memorandum

date July 19, 2021

subject DRAFT Review of 5637 East Mercer Way (MI Treehouse, LLC) – Reasonable Use Exception and Variance Applications (CAO15-001 and VAR18-002)

SITE PLAN
5637 MERCER WAY
MI TREEHOUSE, LLC
 11030 SE 30TH ST
 BELLEVUE, WA 98004

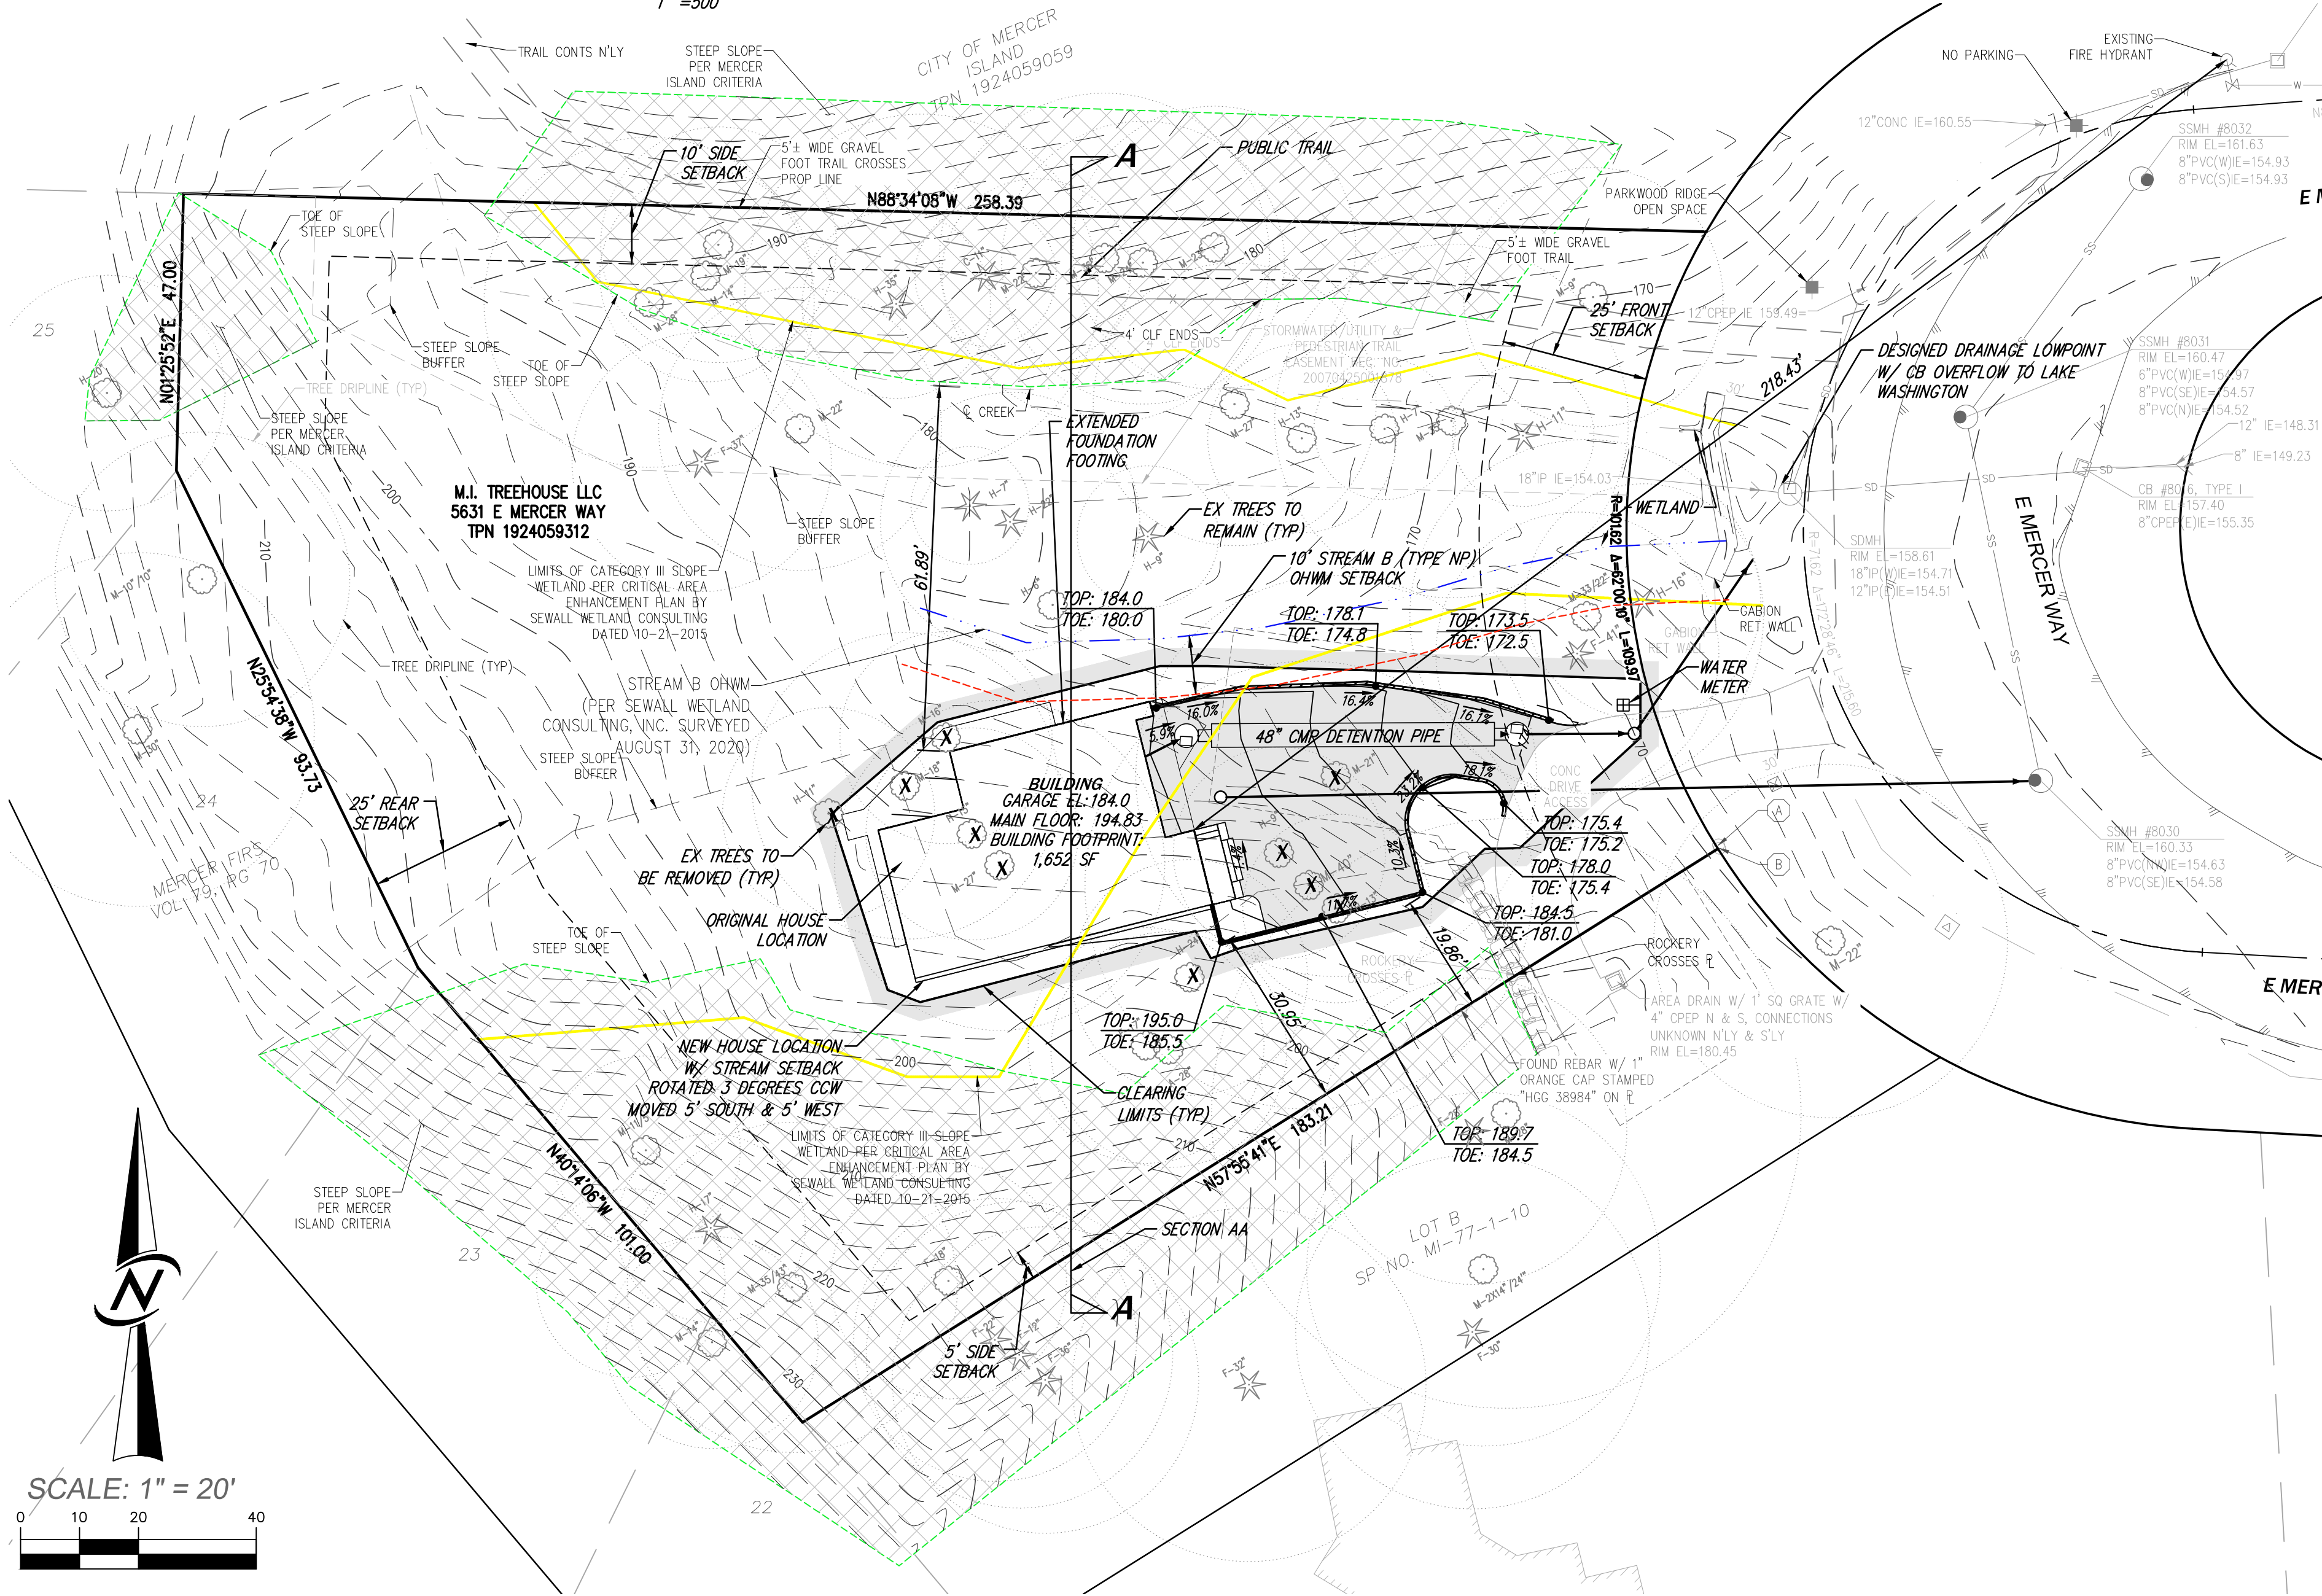
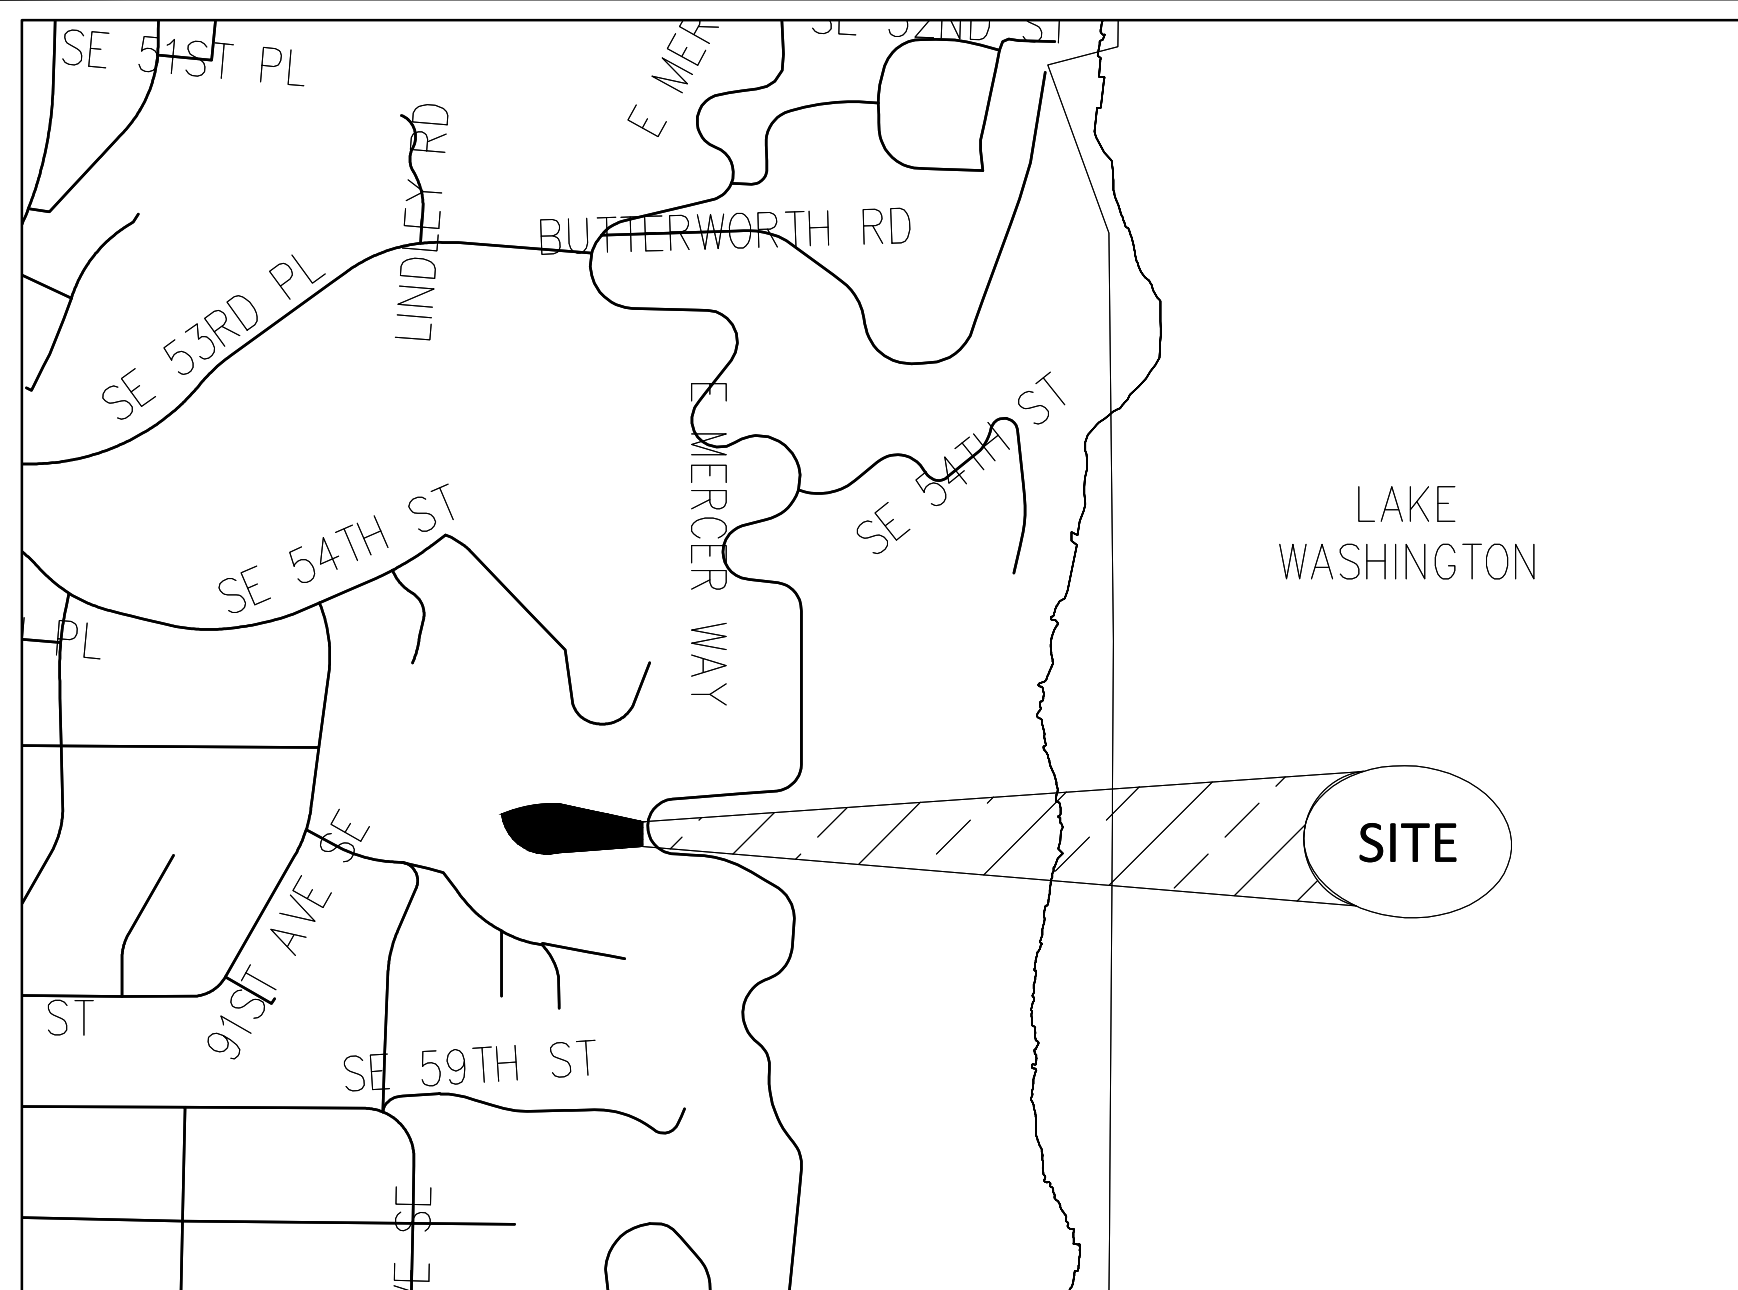
- The revised site plan [Core Design, dated June, 2018 and stamped November 16, 2020] no longer depicts a retaining wall located west and southwest of the proposed residence. ESA previously commented on the wall and associated grading for the building foundation and potential impacts to wetland hydrology. **ESA seeks clarification for the current lack of grading within the slope wetland to accommodate the structure.** If grading is still required, ESA continues to recommend the applicant provide additional details about the onsite drainage system and how it will operate to not artificially drain wetland areas. Alternatively, the applicant can propose an offset from the drainage system that would account for lost wetland hydrology and mitigate impacts through additional credit purchase.

It remains difficult to determine if wetland hydrology will be affected post-project; therefore, ESA recommends that a wetland delineation be conducted in the spring, as part of the Year 5 mitigation monitoring requirement to

determine onsite wetland extents. Should wetland area decrease post-project, ESA recommends the applicant purchase additional credits from the King County Mitigation Reserves Program.

Core Design responded in a letter titled *MI Treehouse – CAO15-001/VAR18-002 Core Project No. XX*, dated May 17, 2021, that indicated no retaining wall would be installed. Instead, the design team shifted the house entry away from the south elevation and to the east and proposes shoring at the edge of excavation to minimize impacts to wetlands and buffers and to avoid disturbance to steep slopes.

Additionally, the design team adjusted the drainage system design to address wetland drainage concerns. Design modifications resulted in a larger diameter, but shorter, detention tank. The tank was also re-orientated to better follow the proposed driveway grading and allow for a shallower excavation with the tank bottom at or above the Stream B elevation.
